1 No. two storey house (resubmission following A/87/18/PL). This application is a Departure from the Development Plan & affects a Public Right of Way.

Land between Ashurst & Badgers Ham Manor Way Angmering

Thank you for your internet representation made on 9th April 2019 which has been recorded as '**an objection**' with the comments as follows:

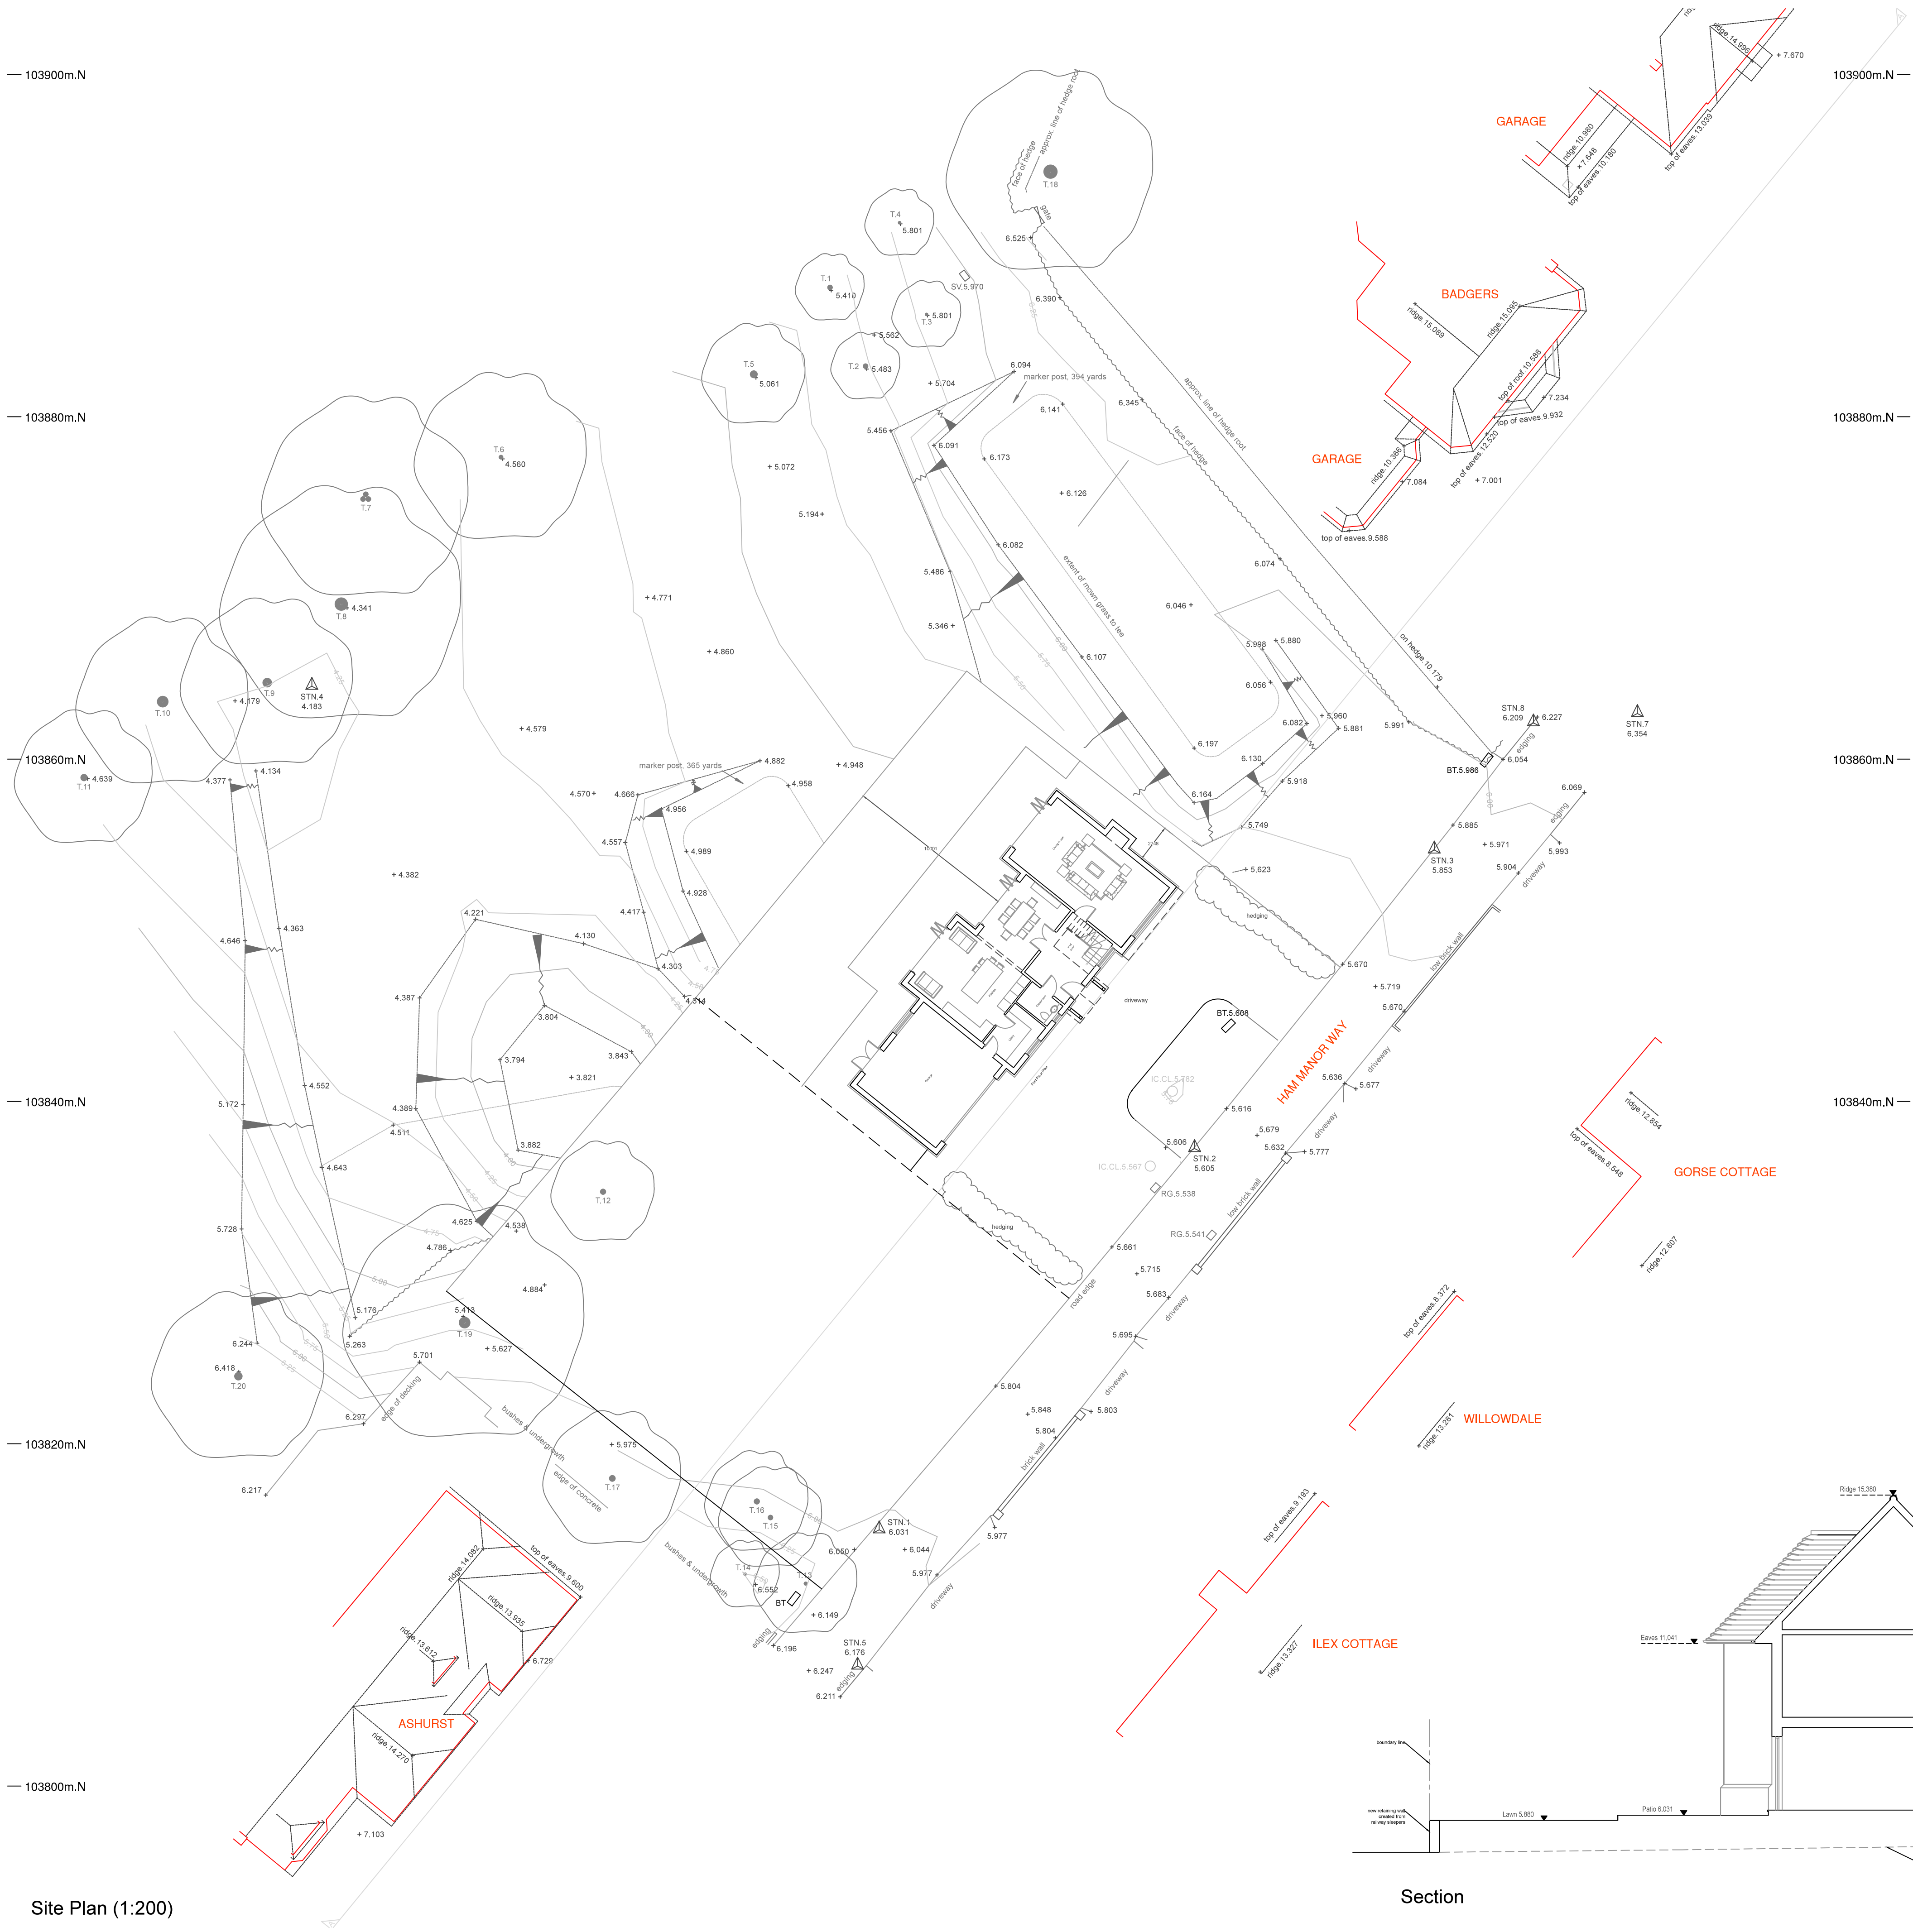
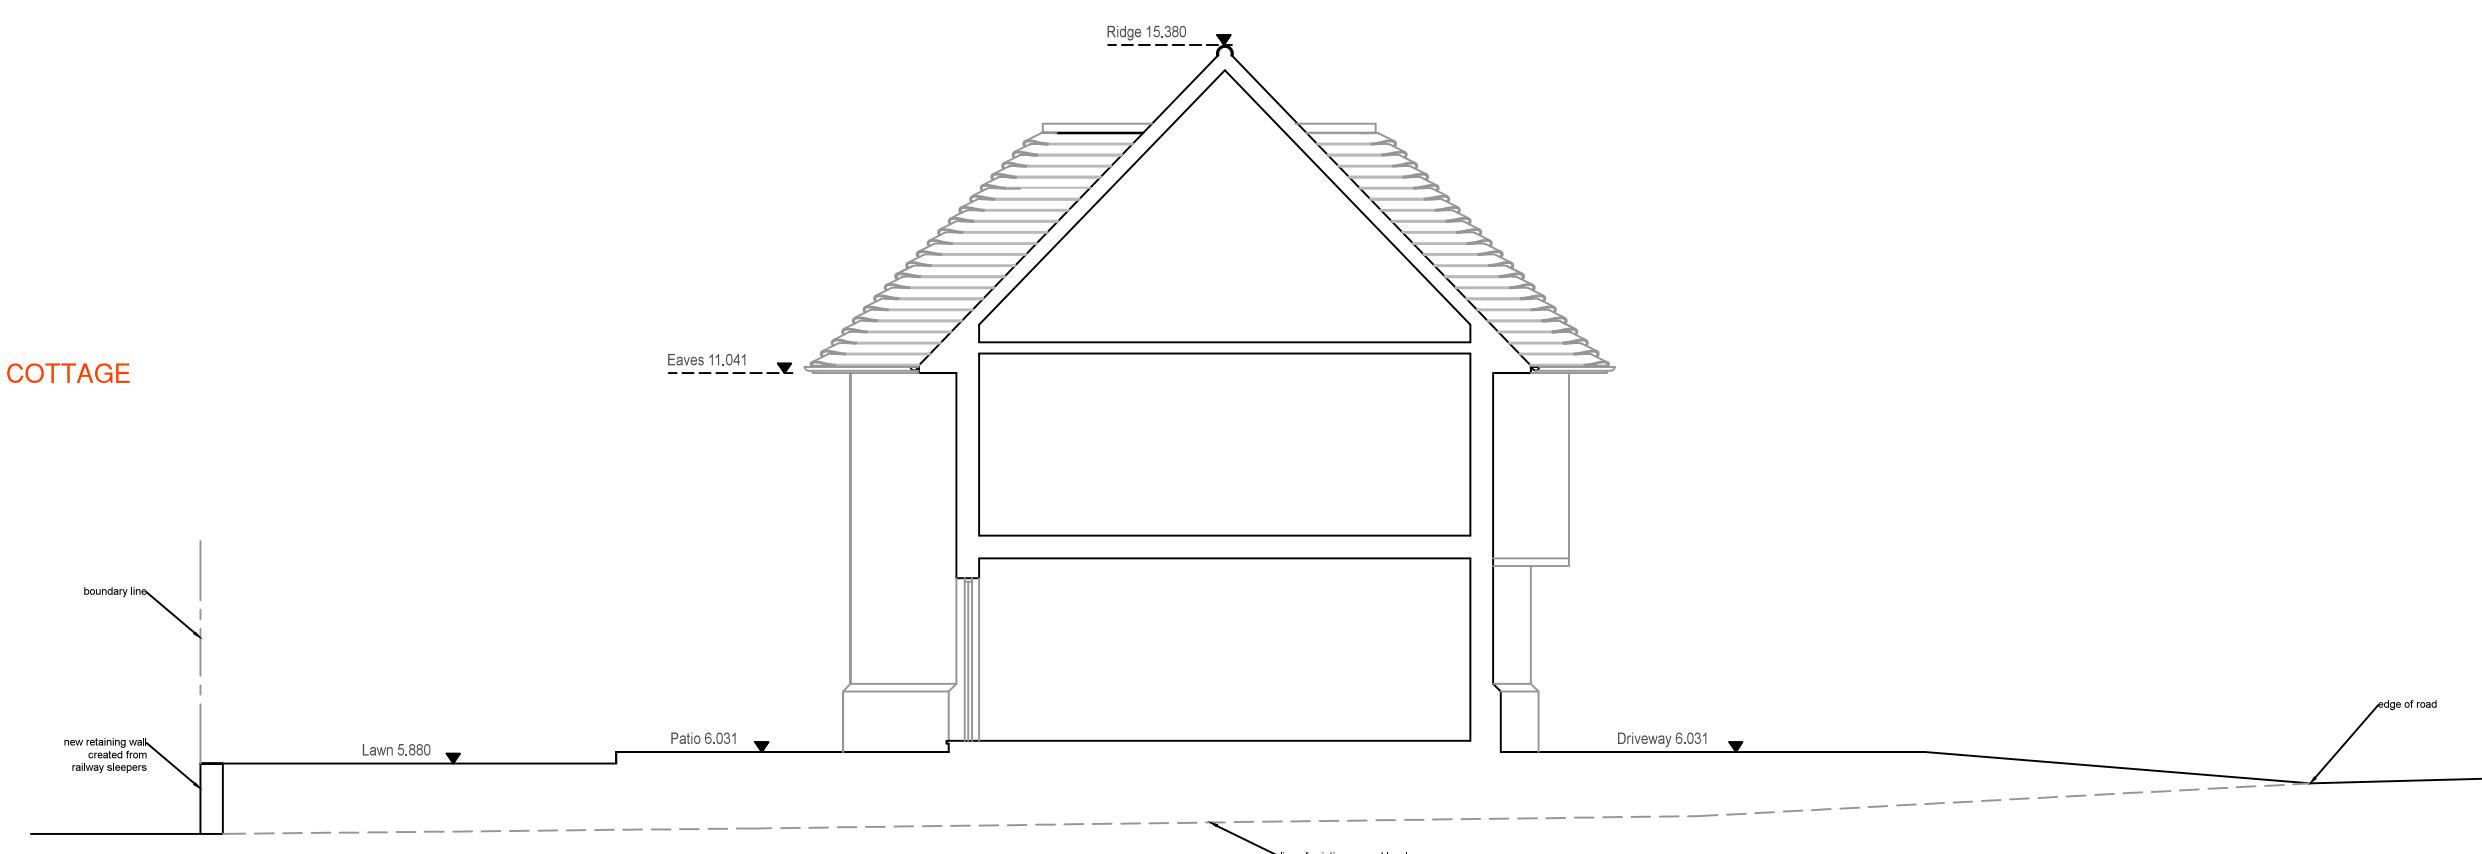
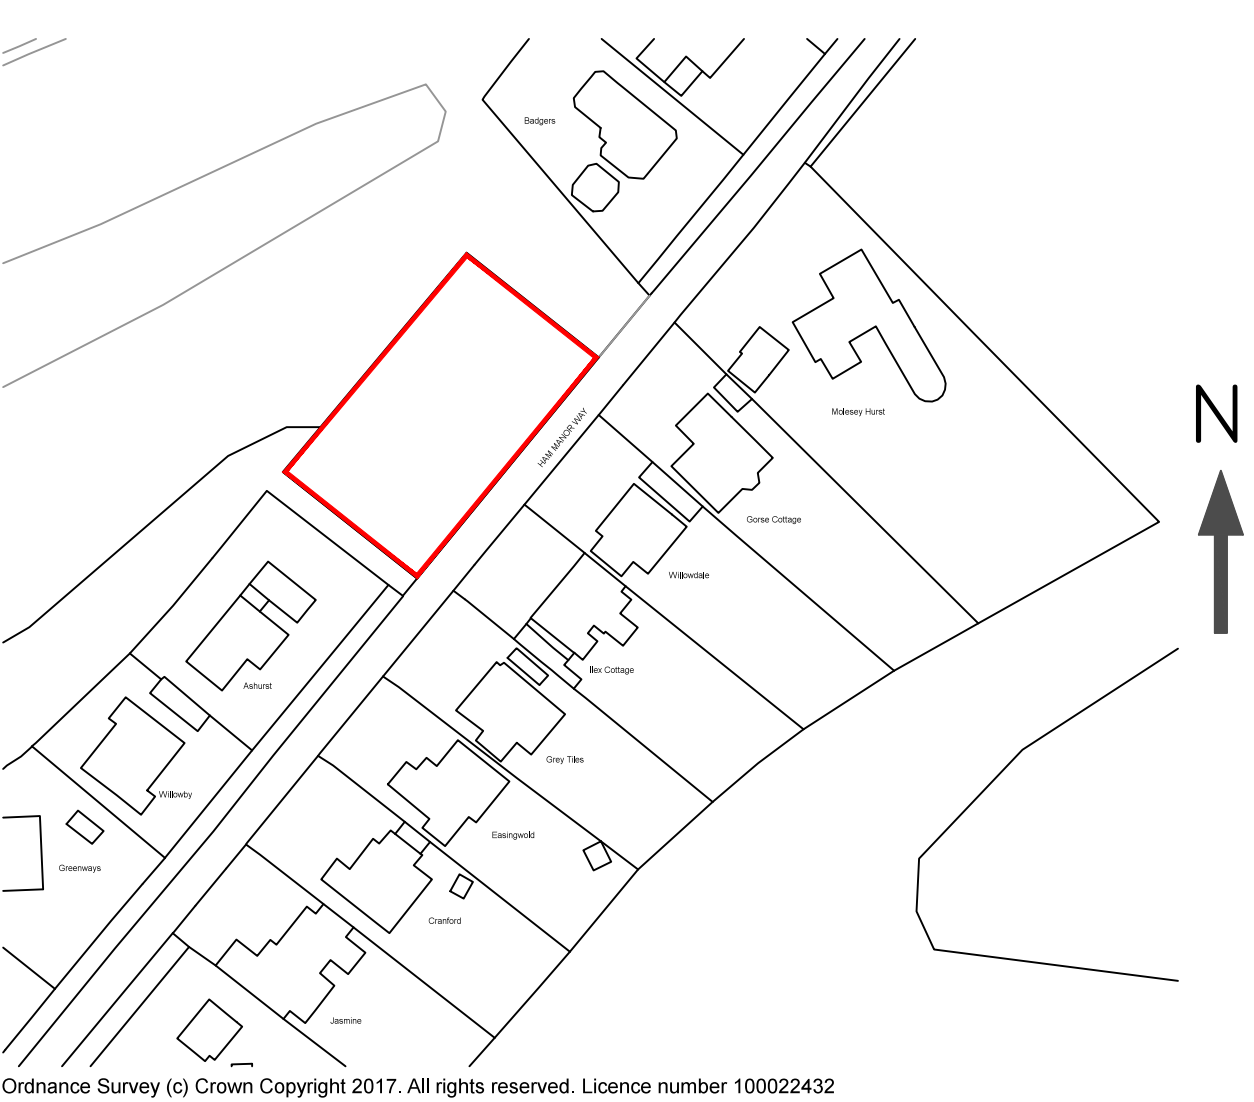
As shown on the submitted plan drawing, drawing number 1202.02.b, the proposed property is positioned a long way forward of the historical build line which can be seen from aerial photo's on Google map. On both sides of Ham Manor Way there is a defined line where properties are not built in front off. If this was allowed it will change the street scene and set a precedent in the future. This again demonstrates the property is too big for the plot size whilst trying to gain a back garden.
